**KIRKLEES METROPOLITAN COUNCIL
INVESTMENT & REGENERATION SERVICE**

DELEGATED DECISION TO DETERMINE PLANNING APPLICATIONS

Reference No: 2020/62/90196/W
Site Address: 7, Woburn Drive, Waterloo, Huddersfield, HD5 0AQ
Description: Erection of single storey side and rear extension
Recommending Officer: Alice Huxley

DECISION – CONDITIONAL FULL PERMISSION

Proposed Elevations

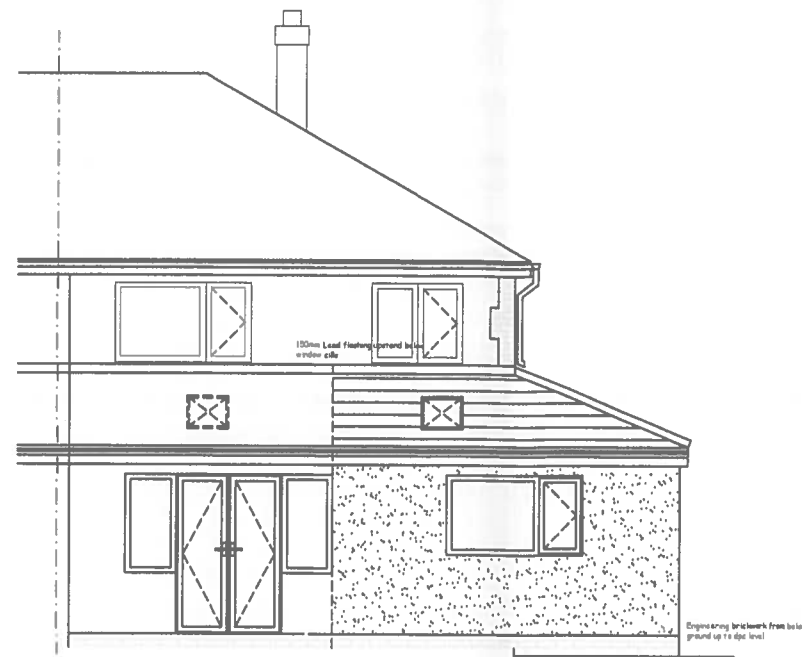
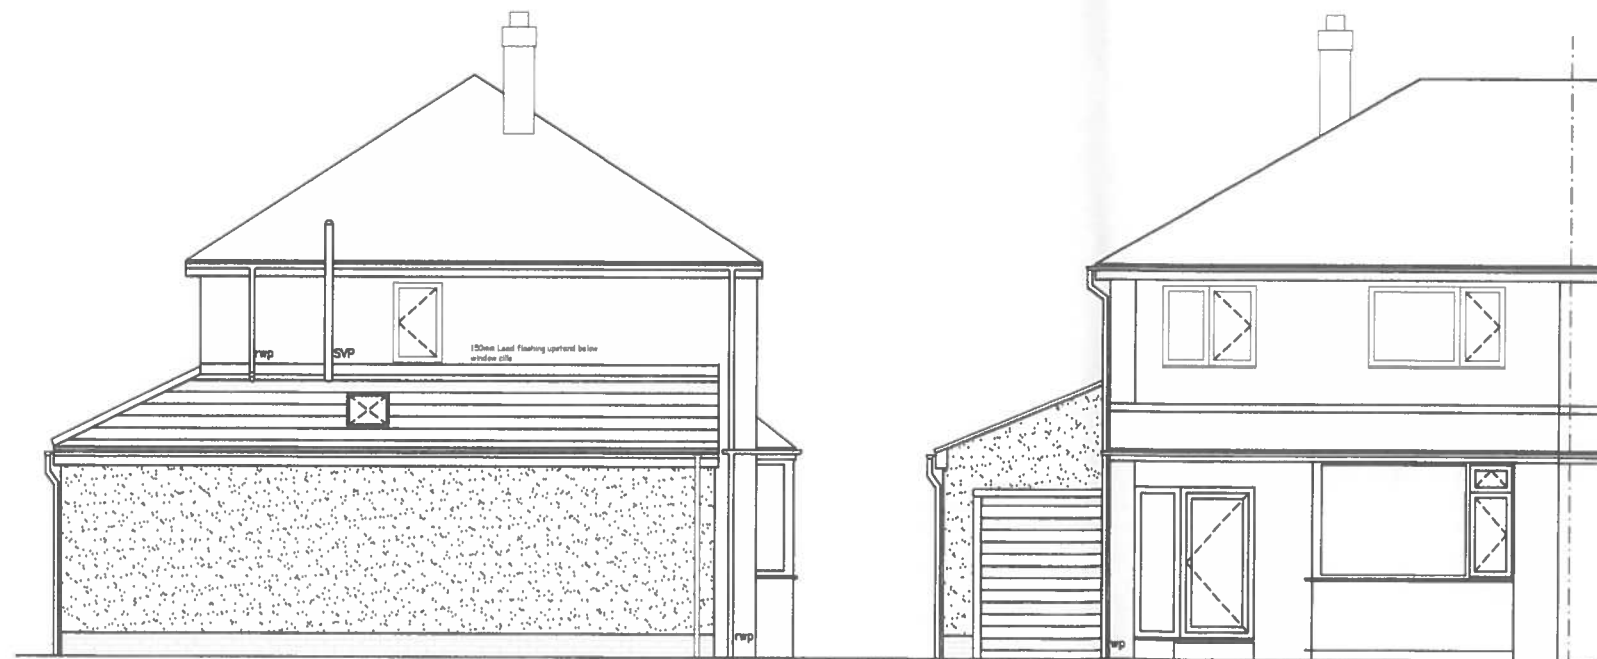
As a result of the above publicity, one representation was received highlighting that the proposed materials nor new boundary treatment is not detailed.

In regards to visual amenity, the single storey side extension would be small and incorporate materials to match the host property in all respects. It has been considered that an inclusion of a garage to the front would not look out of character for the area given that there are other detached and integral garages along Woburn Drive. Regarding the single storey rear extension, this would continue from the existing single storey lean-to at the rear of the property and connect to the single storey side element of the scheme. Furthermore, the single storey rear extension would incorporate materials to match the host dwelling as well as proposed side extension. As such, both elements of the scheme are considered to be subservient to the original dwelling and as such is acceptable in terms of visual amenity.

Officer comment: the applicant has confirmed that the front elevation will be brick constructed with the side and rear elevation being pebble dash render. This is considered to be acceptable as it would harmonise well with the materials used in the construction of the host dwelling. In terms of the proposed boundary treatment, the applicant has also confirmed that there will be a wall approximately 1m high on the south boundary to the front garden and 1.8m high fencing on the south boundary to the rear garden.

3. The external walls and roofing materials of the extension hereby approved shall in all respects match those used in the construction of the existing building.

Drawing Description: -
Proposed Site Plan

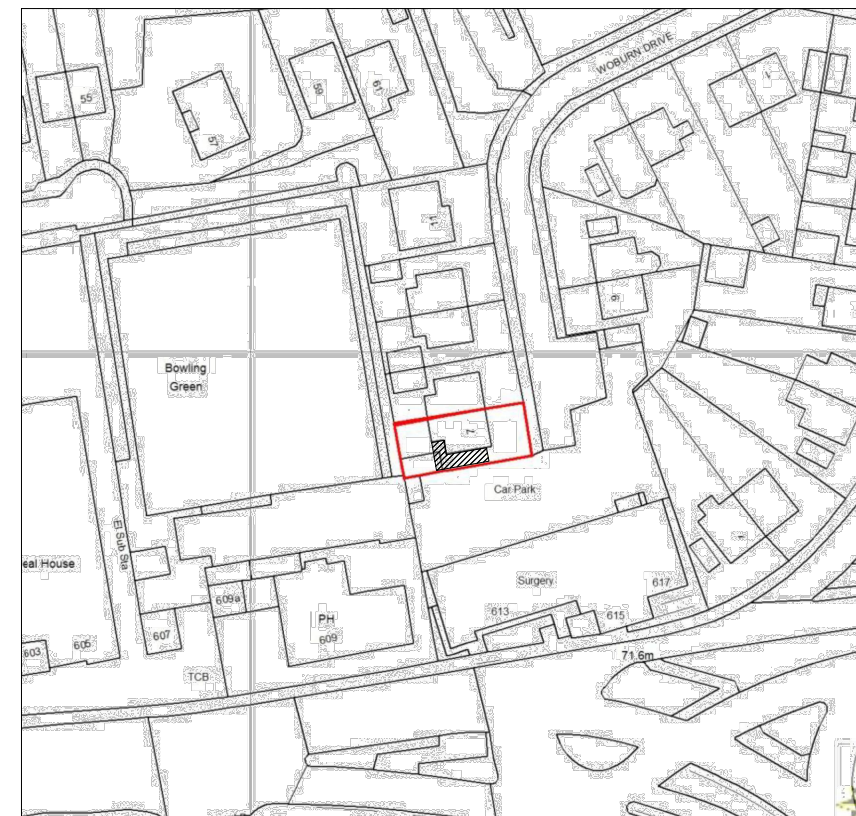
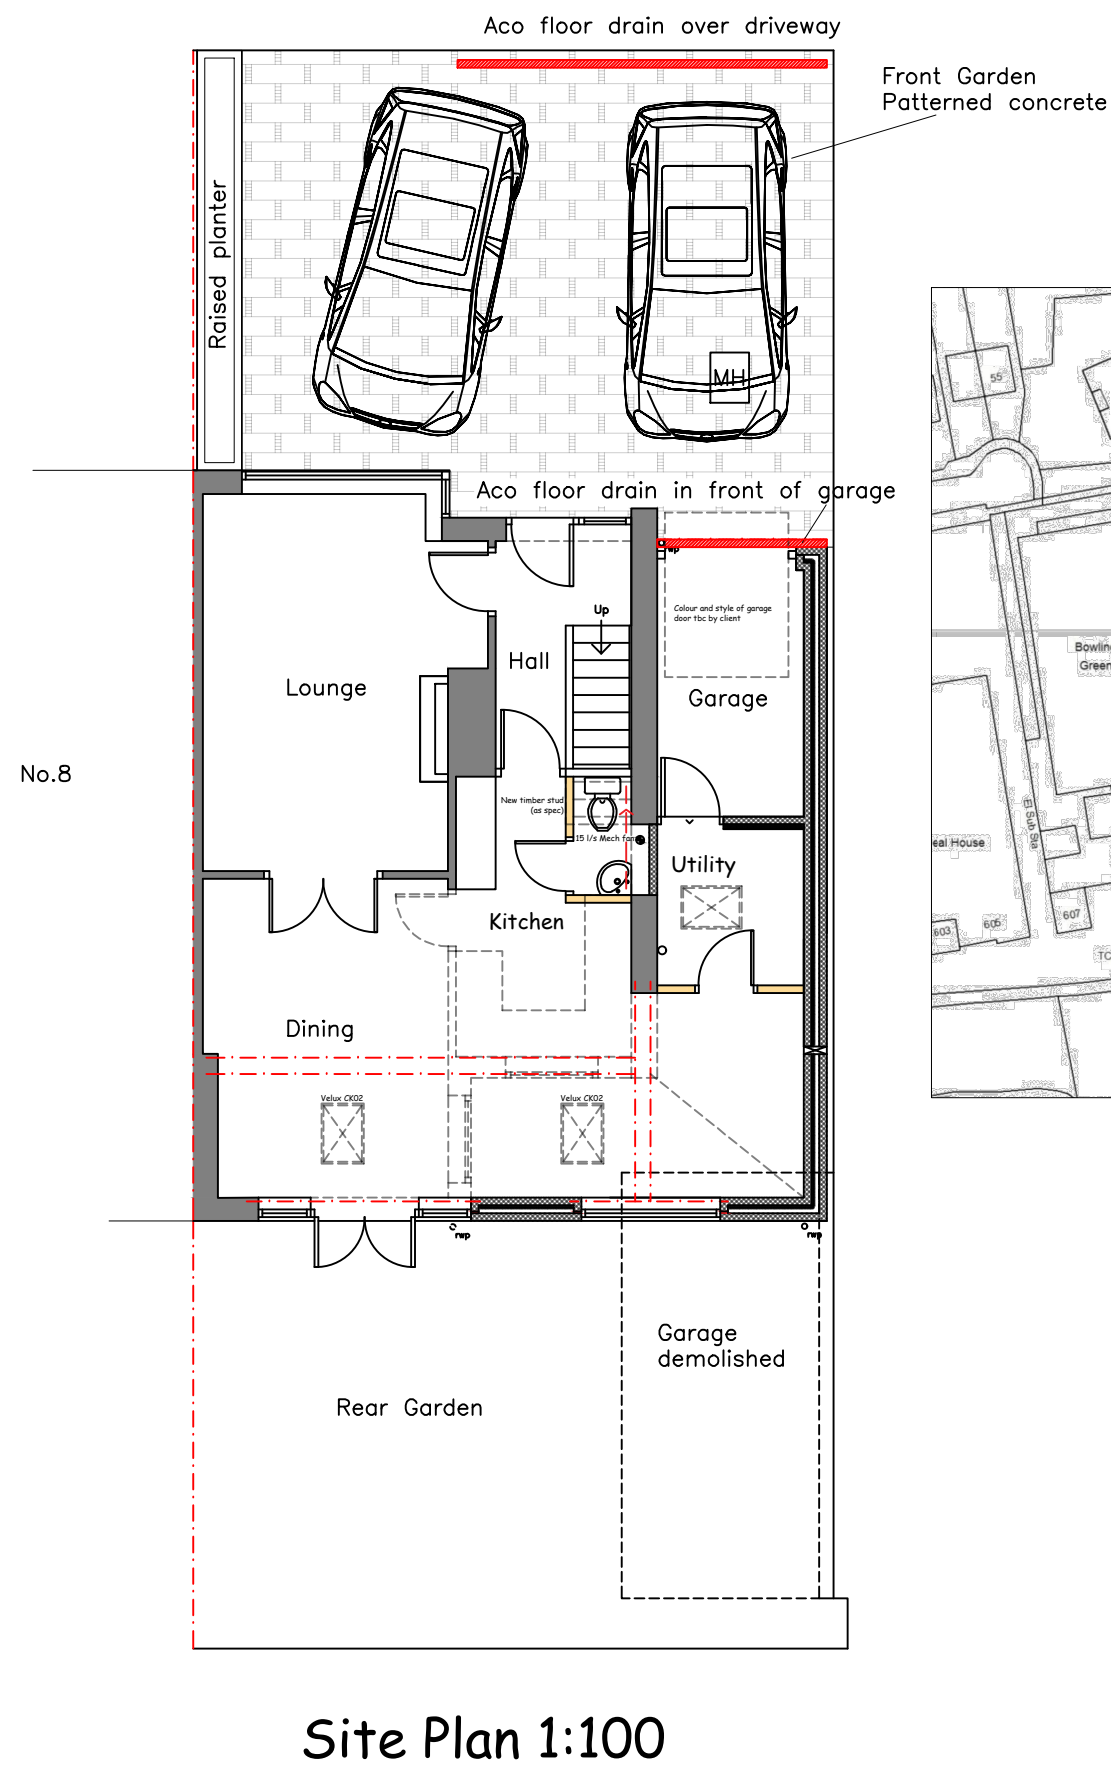
Highways Development Management – recommend that an additional parking space is provided to the front of the premises to compensate for the loss of existing off-street parking.

Highways Development Management were formally consulted and it is noted that whilst the proposal does not increase the no. of bedrooms on site, the proposed side extension would result in the loss of a minimum of one off-road parking space. On-street parking at this location is likely to be at a premium due to the proximity of the doctor's surgery. To overcome any concerns regarding matters of parking and highway safety, the front garden is to be surfaced and drained as shown on drawing no. 07A received on 17/03/2020 to provide additional off-road parking.

6. The proposed parking shown on the proposed site plan (plan ref: 07A) received on 17/03/2020 shall be completed before the single storey side and

rear extension are brought into use. The parking shall be kept free of obstructions and retained thereafter.
